# ARBORIST REPORT

**Addendum to report dated**

June 7, 2023

3036 67<sup>th</sup> Avenue SE  
Mercer Island, WA

<

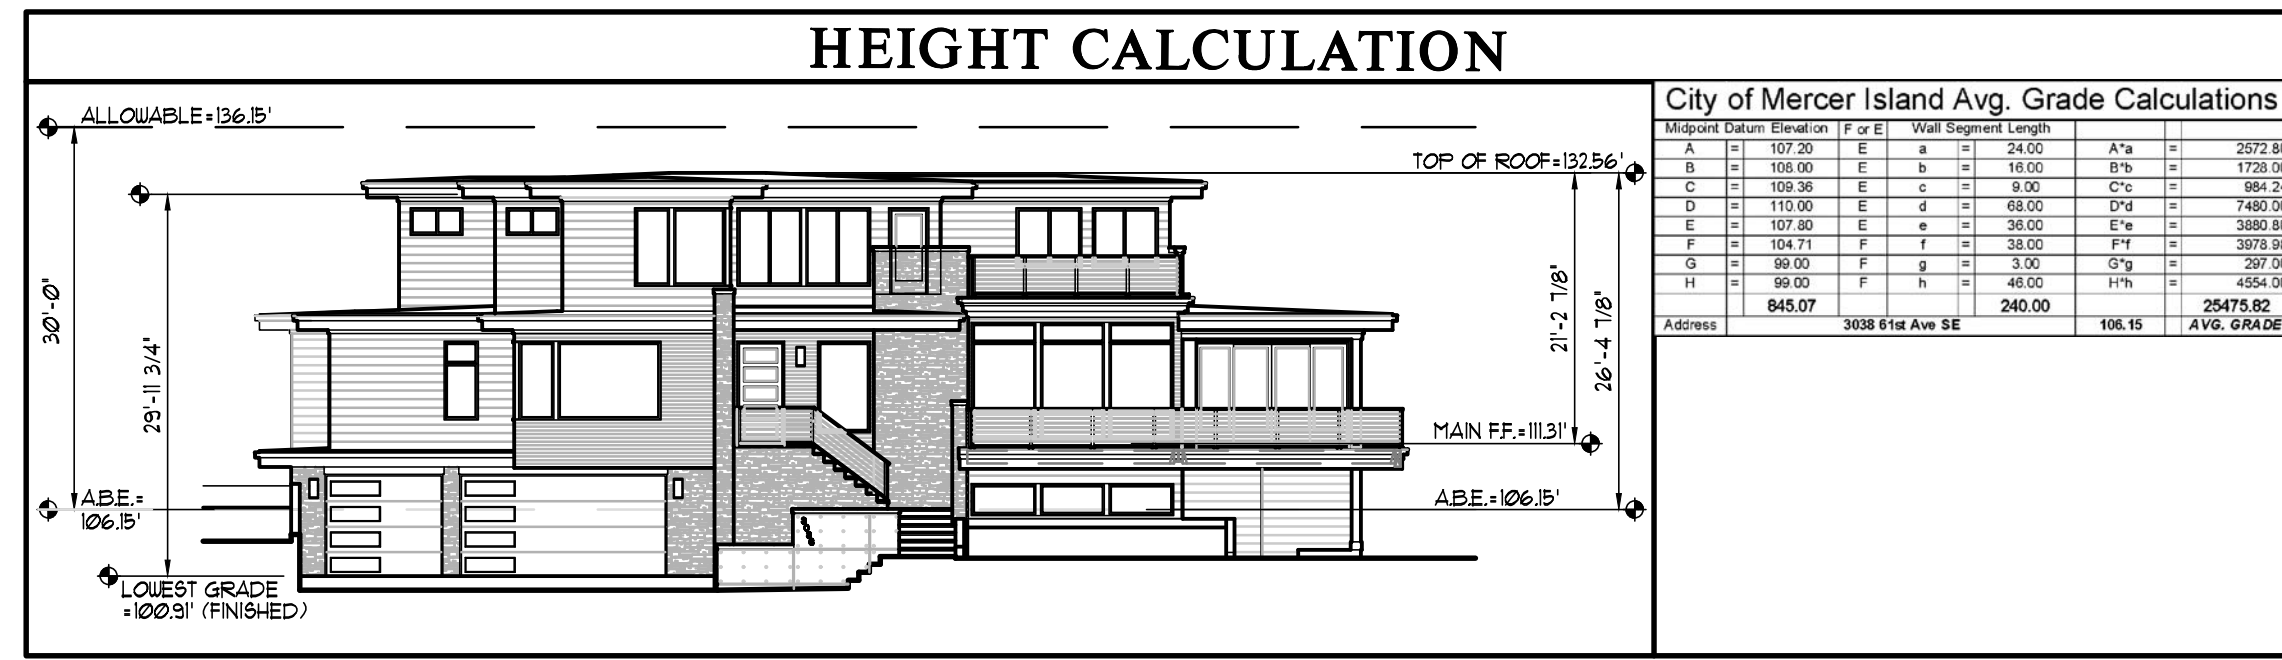
Please reference the initial arborist report for the above referenced property, said report dated October 11, 2022. I have reviewed Site Plan A1.1, revision date 6/7/2023.

Plan A1.1 accurately details the existing trees as well as the location of proposed replacement trees. Two (2) on-site trees will be retained and nine (9) replacement trees will be planted. Six of the nine replacement trees are native species.

Plan A1.1 also details the location of an off-site tree located approximately 8' south of the south property line. This tree has overhanging limbs but only because the tree is failing and leaning dramatically to the north. See initial arborist report for additional details.

The above referenced initial arborist report included Tree protection Measures, including Tree Protection Fencing and on-site arborist monitoring of excavation activity. These protection measures are included on Plan Sheet A1.1. The location of proposed tree protection fencing is detailed on this plan sheet, said location is just outside of the trees drip-line radius.
